Our ref: HA/2019/121822/01-L01
Your ref: LU/328/19/PL
Date: 04 December 2019

VARIATION OF CONDITION 2 IMPOSED UNDER LU/154/19/PL RELATING TO APPROVED PLANS: CHANGE OF USE OF GROUND FLOOR FROM BANKING (A2 FINANCIAL & PROFESSIONAL SERVICES) TO RETAIL (A1 SHOPS), PERMITTED DEVELOPMENT TO FORM 2 NO. FLATS ABOVE PLUS 1 NO. FURTHER FLAT & EXTENSION TO FORM 1 NO. TWO STOREY DWELLING & ANCILLARY ALTERATIONS.

52 HIGH STREET, LITTLEHAMPTON, BN17 5SY

DWG. NO. / 011218 / TP.01 REV.'B'

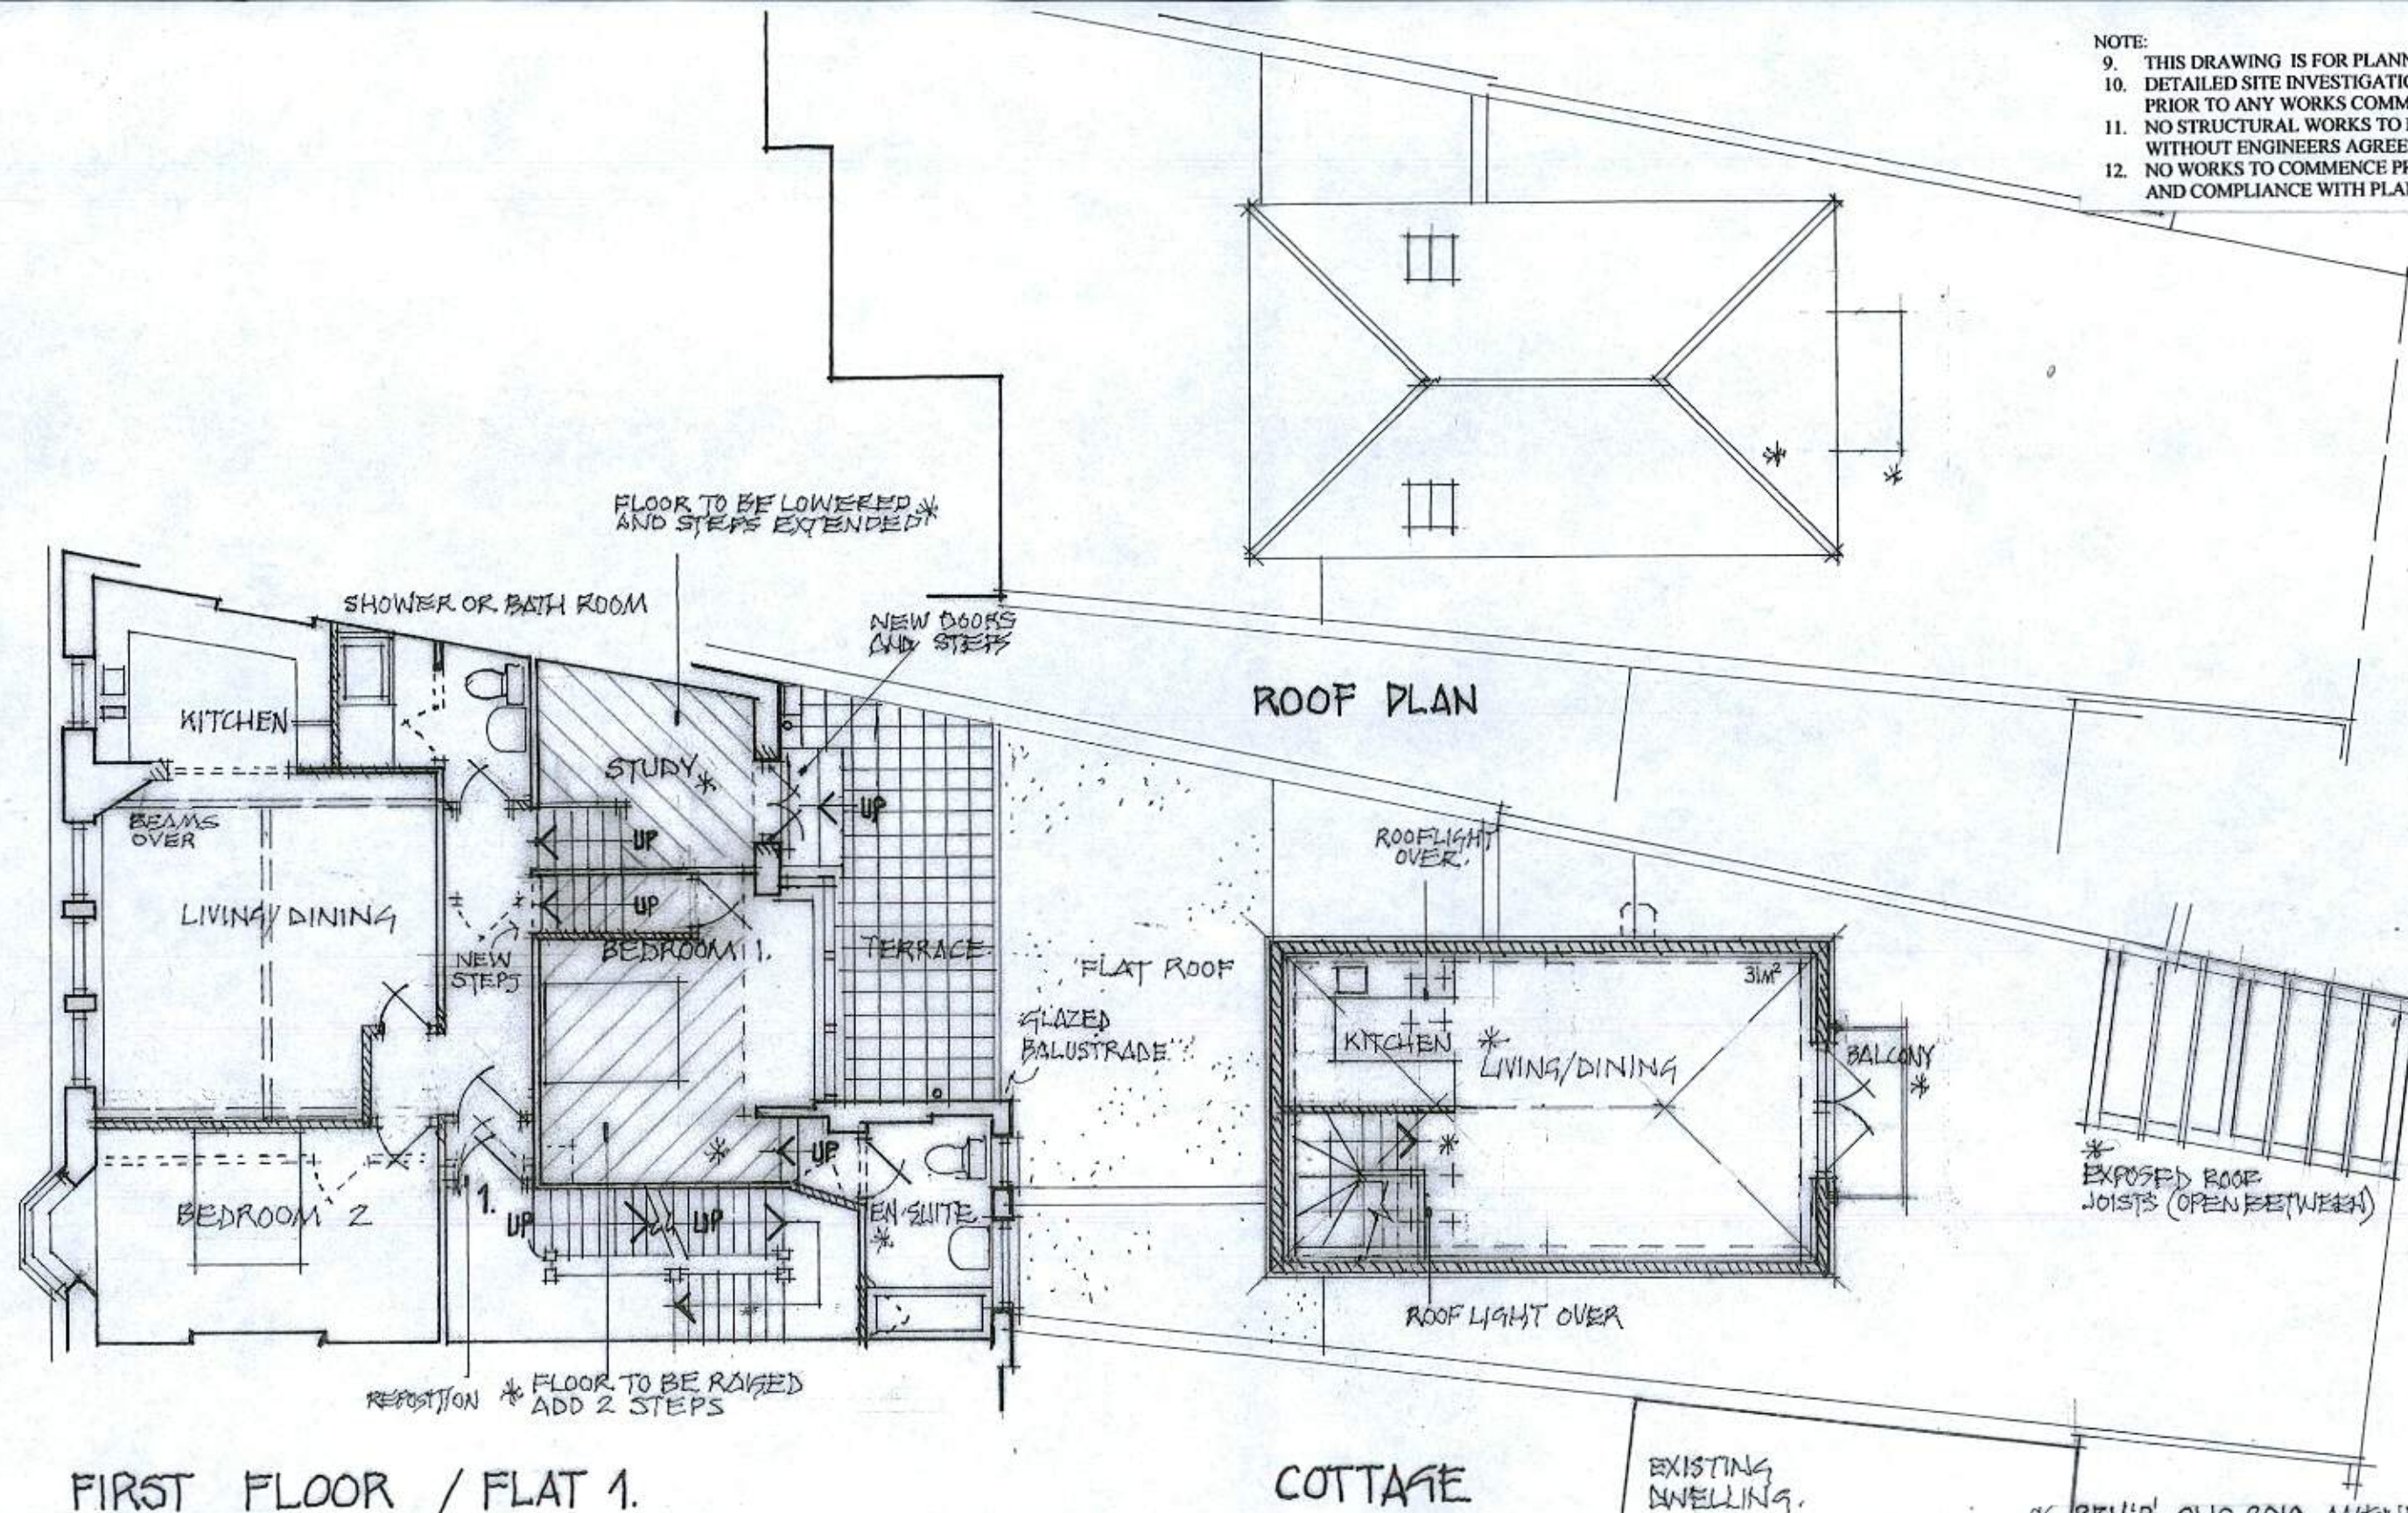
Following our previous response, a condition was imposed that sleeping accommodation was placed on the first floor and above. In the submitted revised drawings, bedrooms are now being placed on the ground floor, presenting an increased flood risk to occupants for the lifetime of the development.

To overcome our objection, the applicant should submit evidence to demonstrate that the proposal will not pose a risk to life as highlighted above. We would recommend that the applicant reverts to the original plans that we previously conditioned and commented on.
